# CITY OF ALBUQUERQUE

May 7, 2019

**Re: 601 Commercial renovation**  
**601 Commercial St. NE Albuquerque NM**  
**Traffic Circulation Layout**  
Engineer's/Architect's Stamp **04-22-2019 (J14D124)**

TRAFFIC CIRCULATION LAYOUT
TCL-1
SHEET 01 OF 02

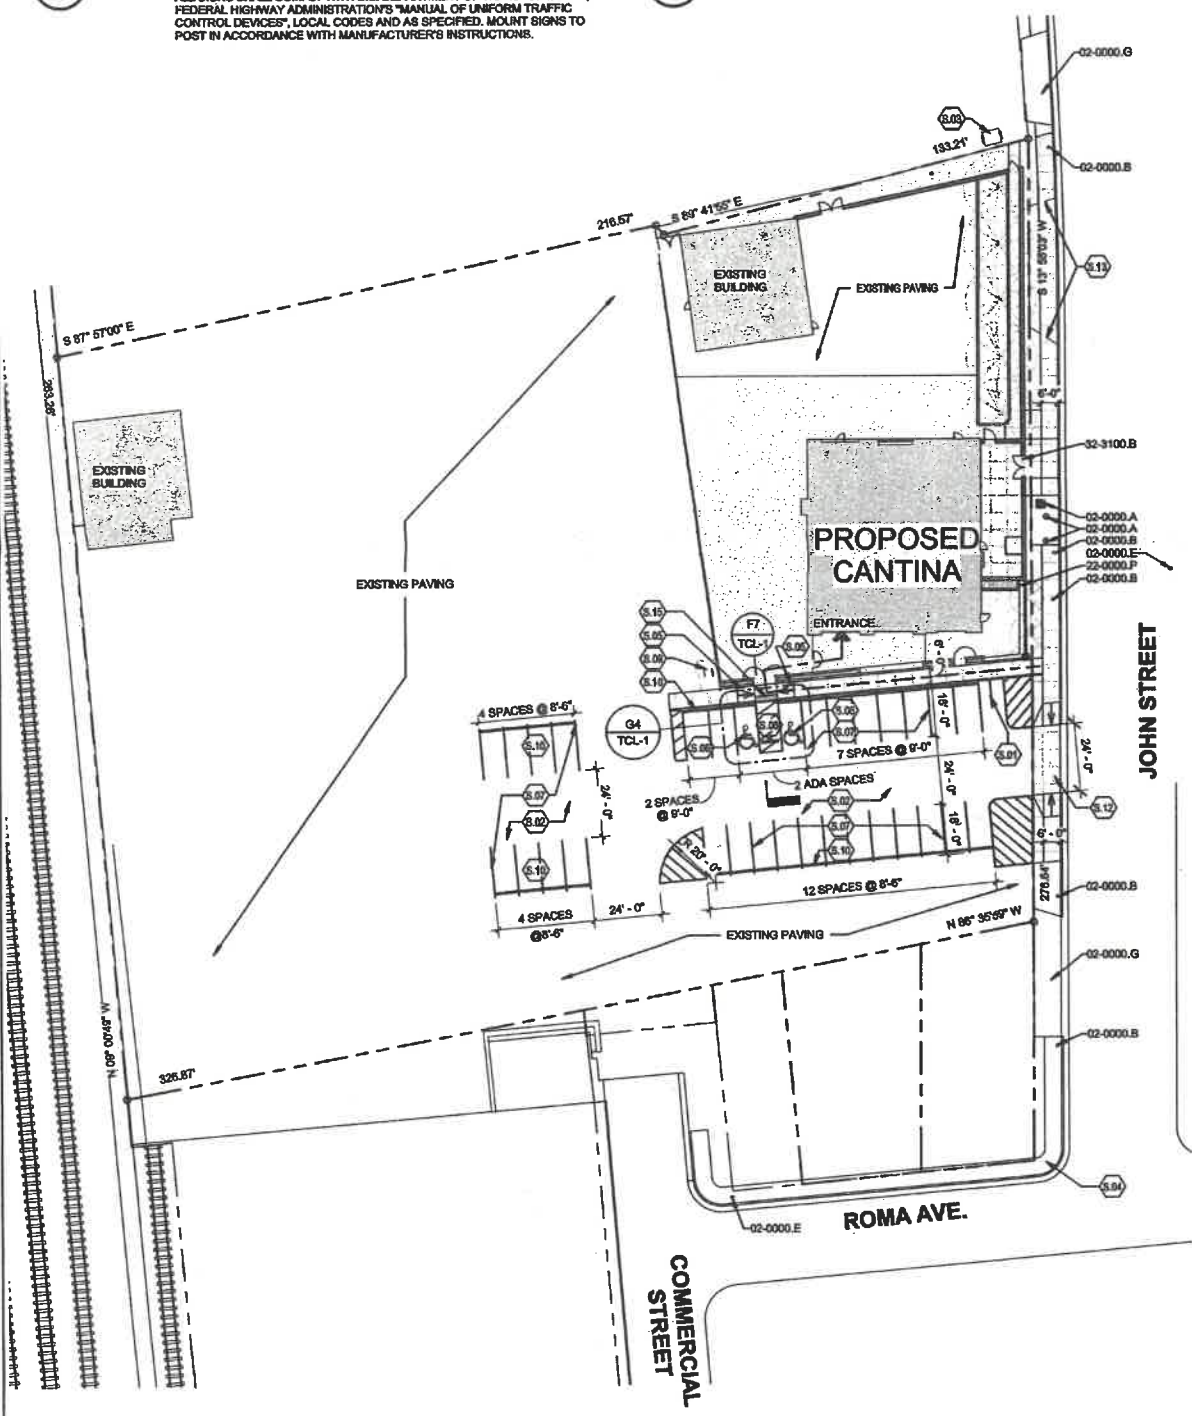
The TCL submittal received 05-07-19 is approved for Building Permit with a **condition of checking for concrete car stoppers at the time of CO**. A copy of the stamped and signed plan will be needed for each of the building permit plans. Please keep the original to be used for certification of the site for final C.O. for Transportation.
